DRB Application No.: **06DRB-00002 (P&F)**

Project # **1002002**

Project Name: **SAN MATEO DEL NORTE**

**RE: San Mateo Del Norte/p&f plat**

Easement Details

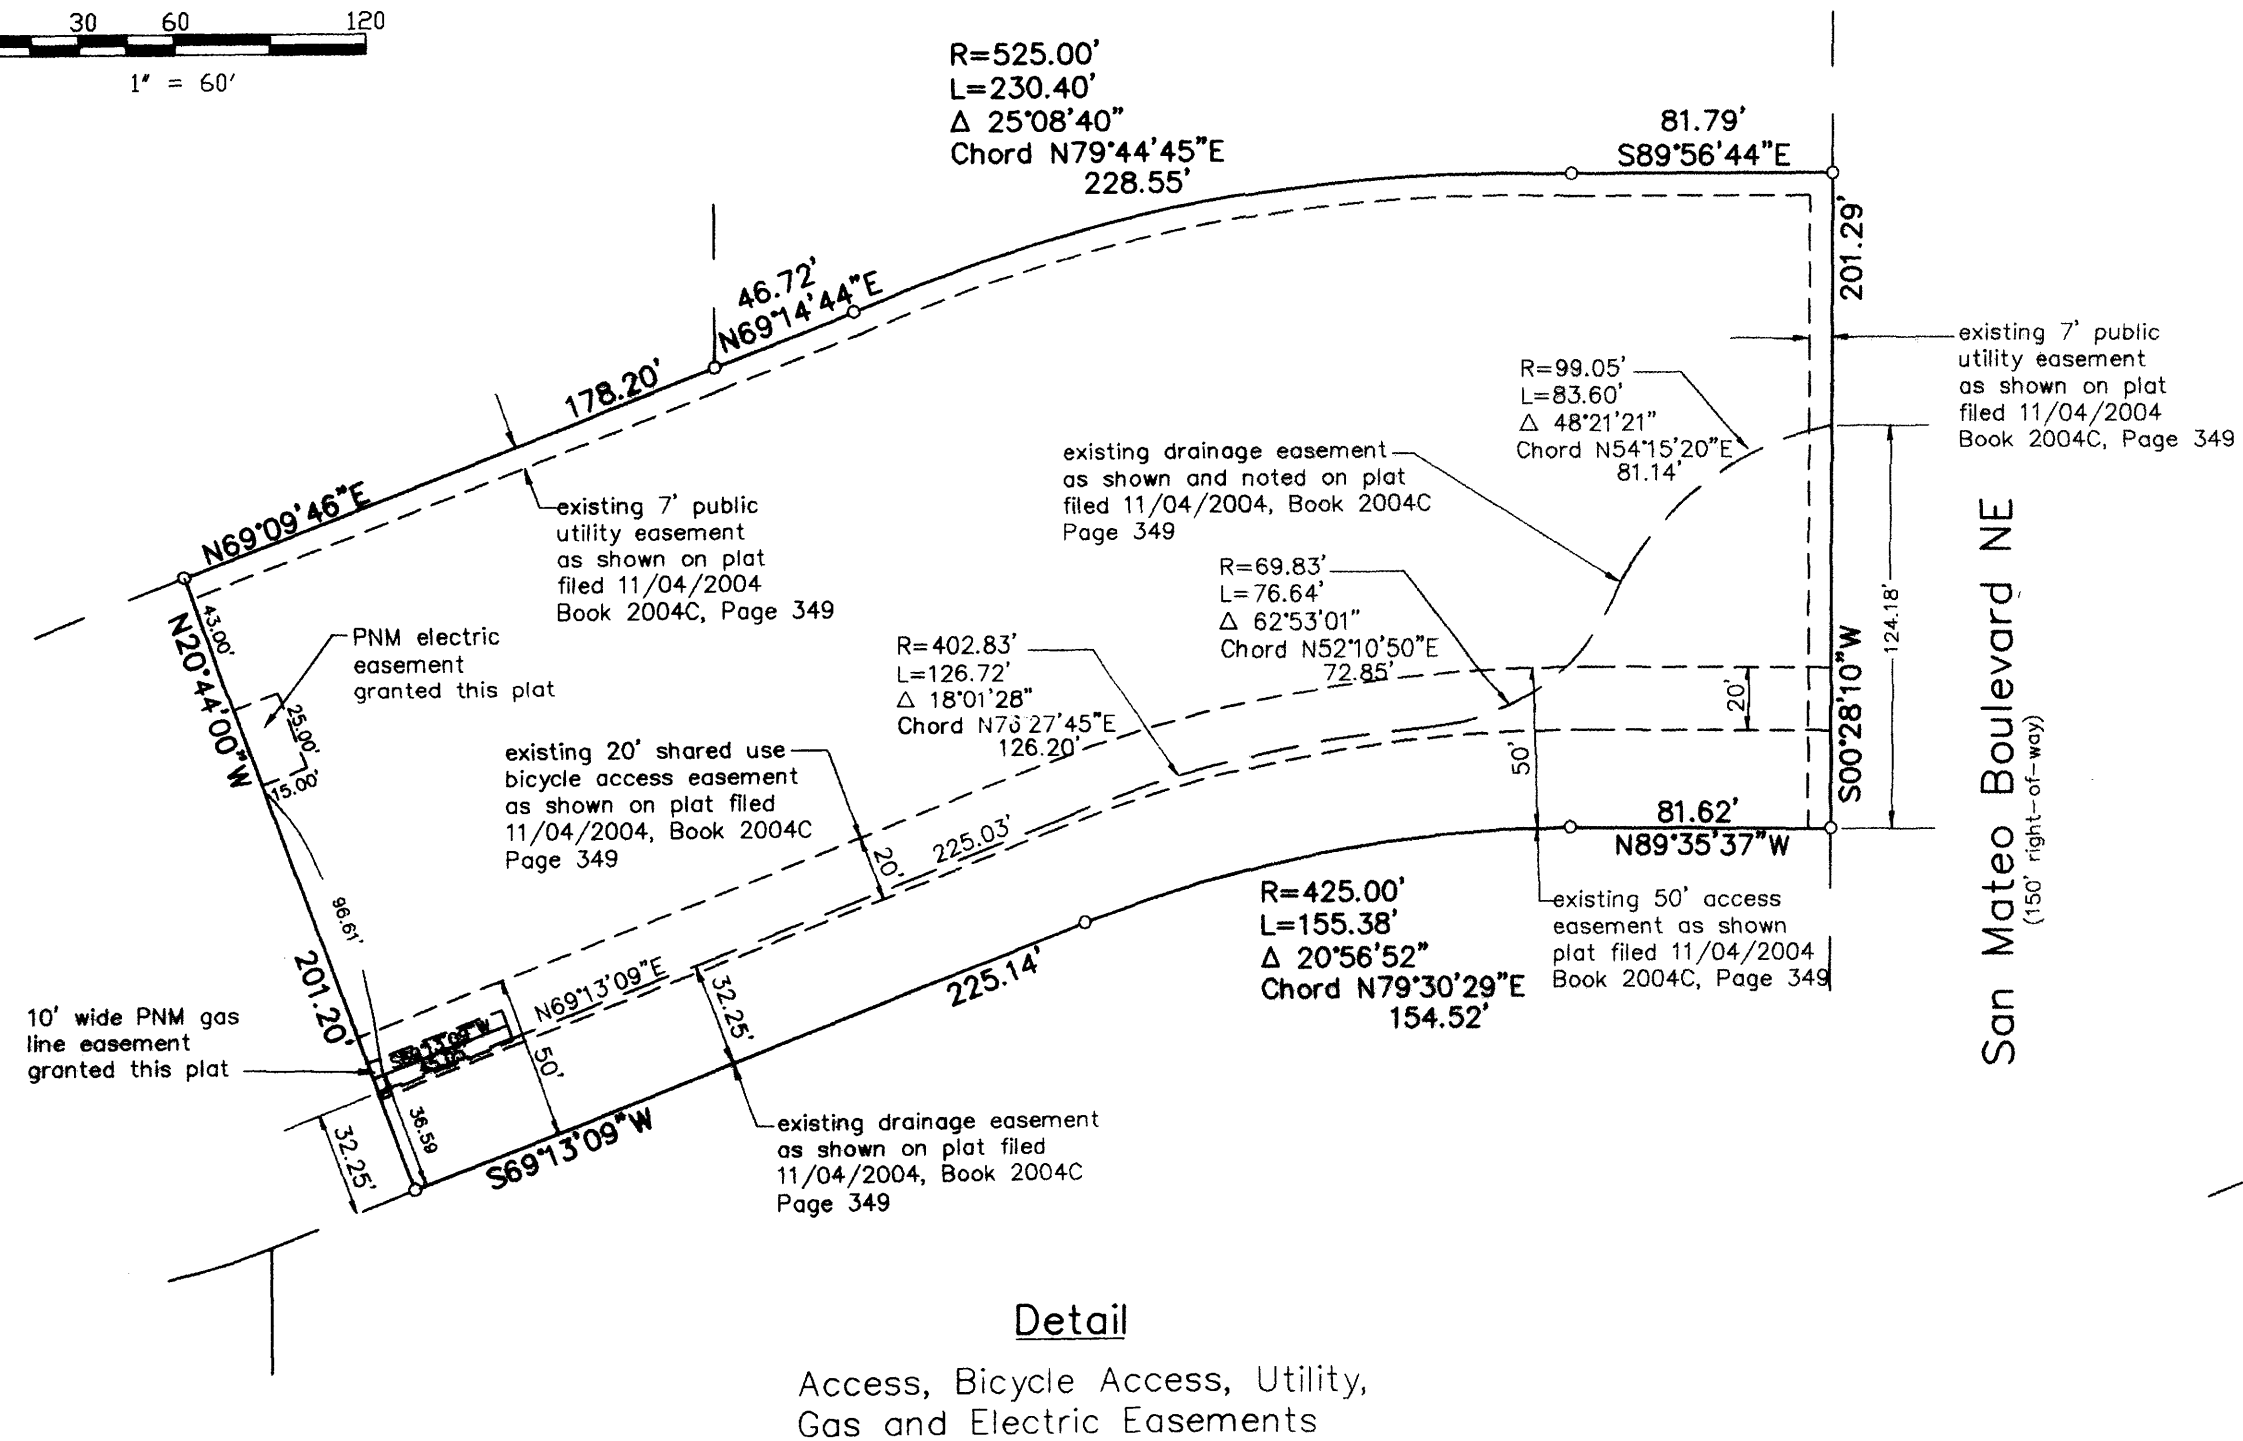
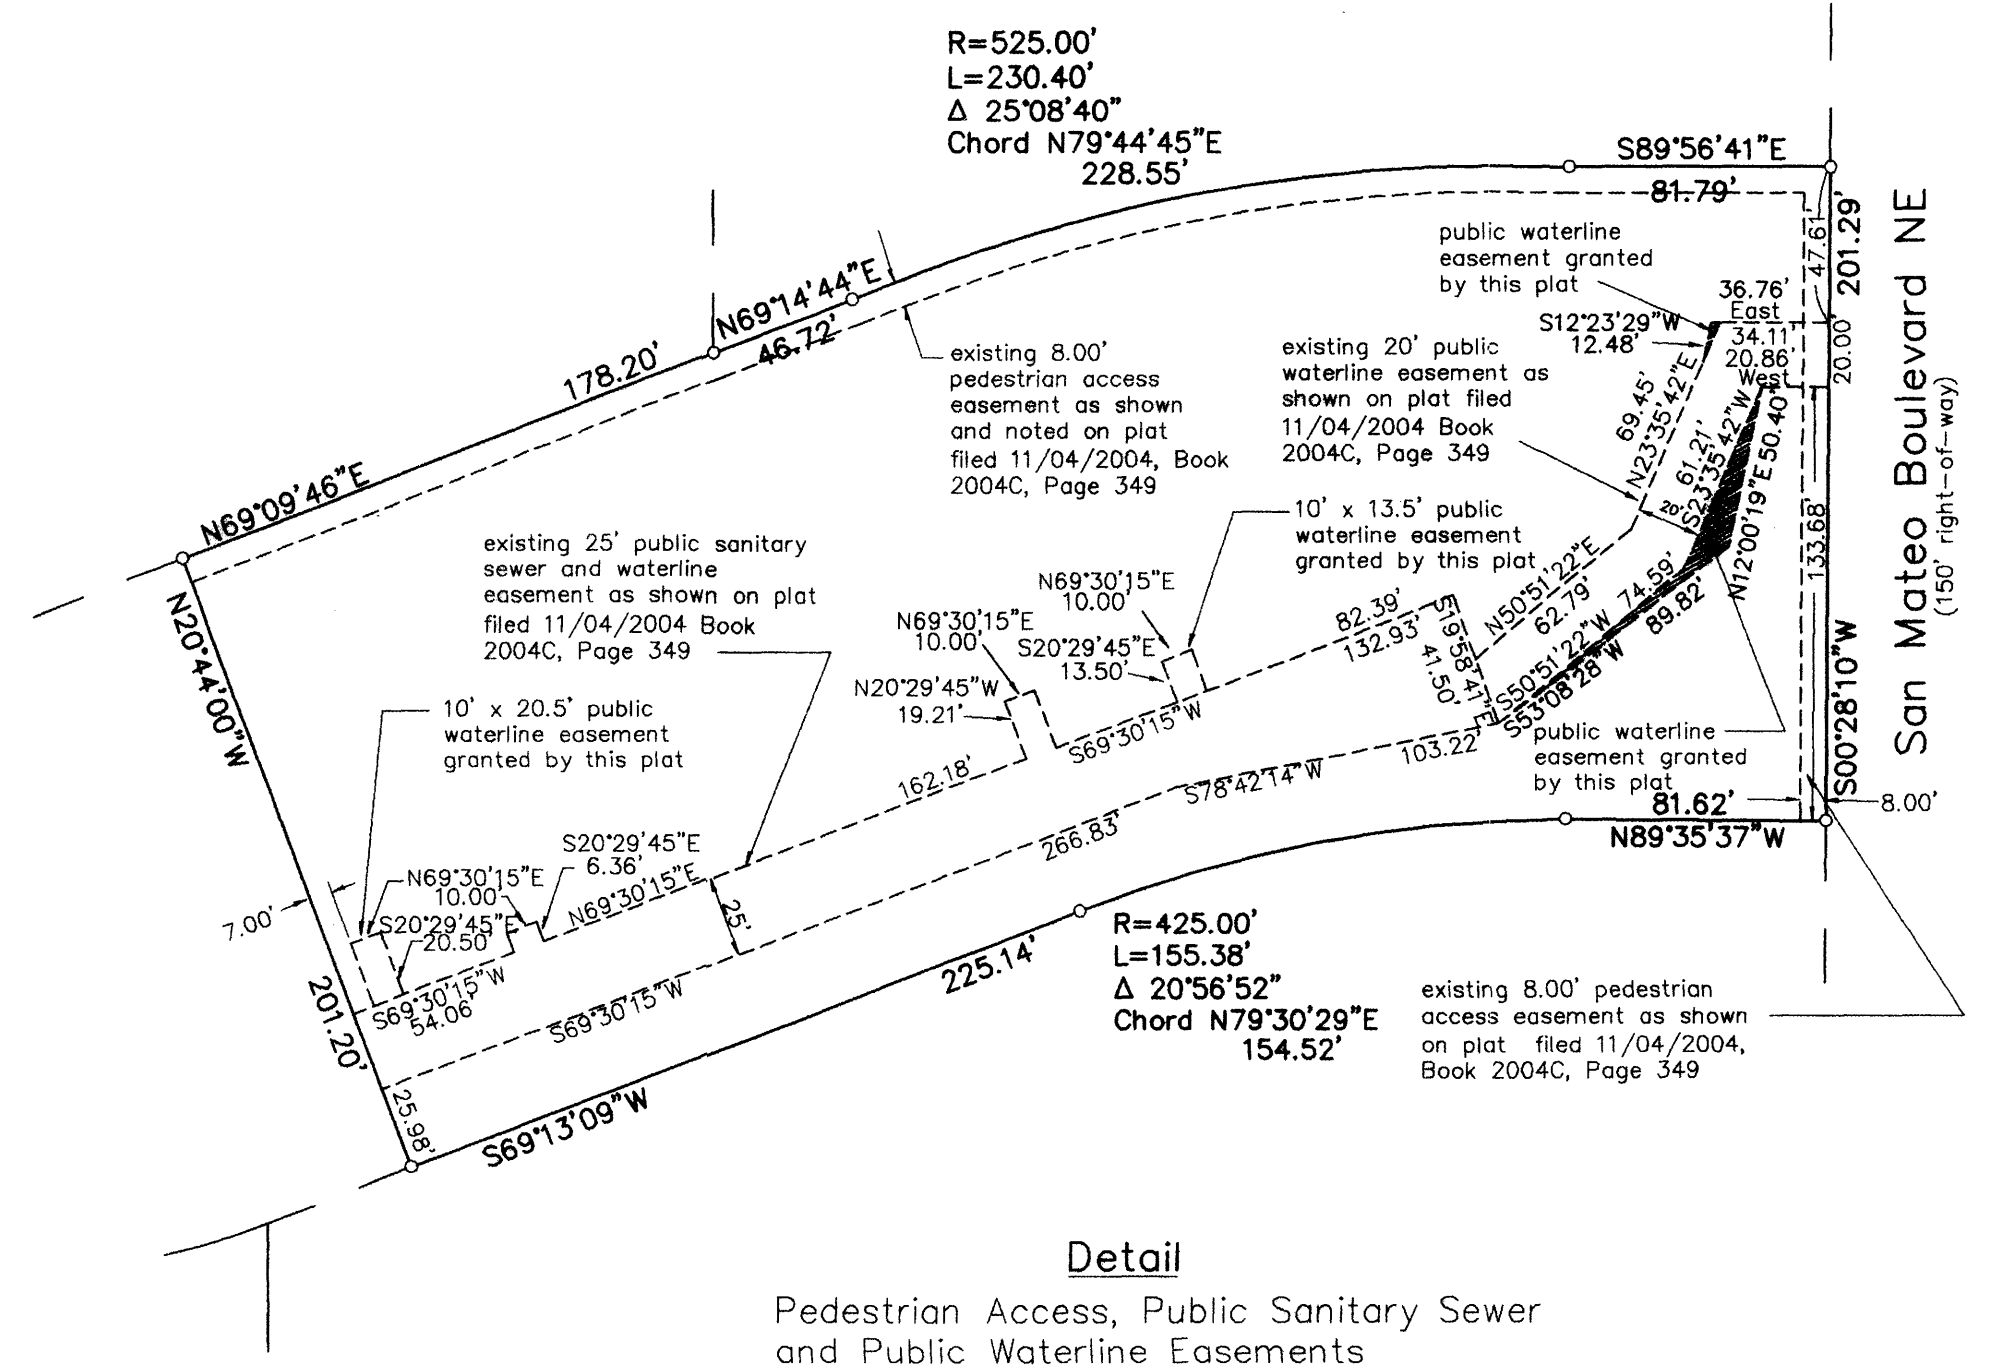
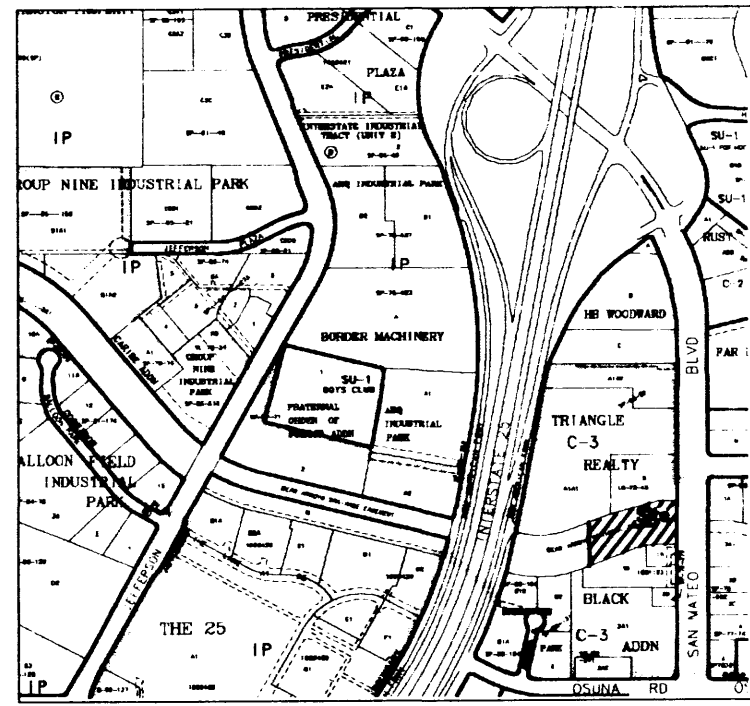
PLANNING (Last to sign): *Record plat*  
*Add public to drainage easement on sheet 3*

FORSTBAUER SURVEYING LLC agent(s) for RETAIL DEVELOPMENT LLC request(s) the above action(s) for all or a portion of Lot(s) 2 & 3, **SAN MATEO DEL NORTE**, zoned C-3, located on SAN MATEO BLVD NE, between OSUNA RD NE and ACADEMY BLVD NE containing approximately 3 acre(s). [REF: 04-DRB-00805] (E-17) **THE PRELIMINARY AND FINAL PLAT WAS APPROVED WITH FINAL SIGN OFF DELEGATED TO PLANNING TO RECORD THE PLAT AND TO CHECK FOR THE ADDITION OF A PUBLIC DRAINAGE EASEMENT ON SHEET 3.**
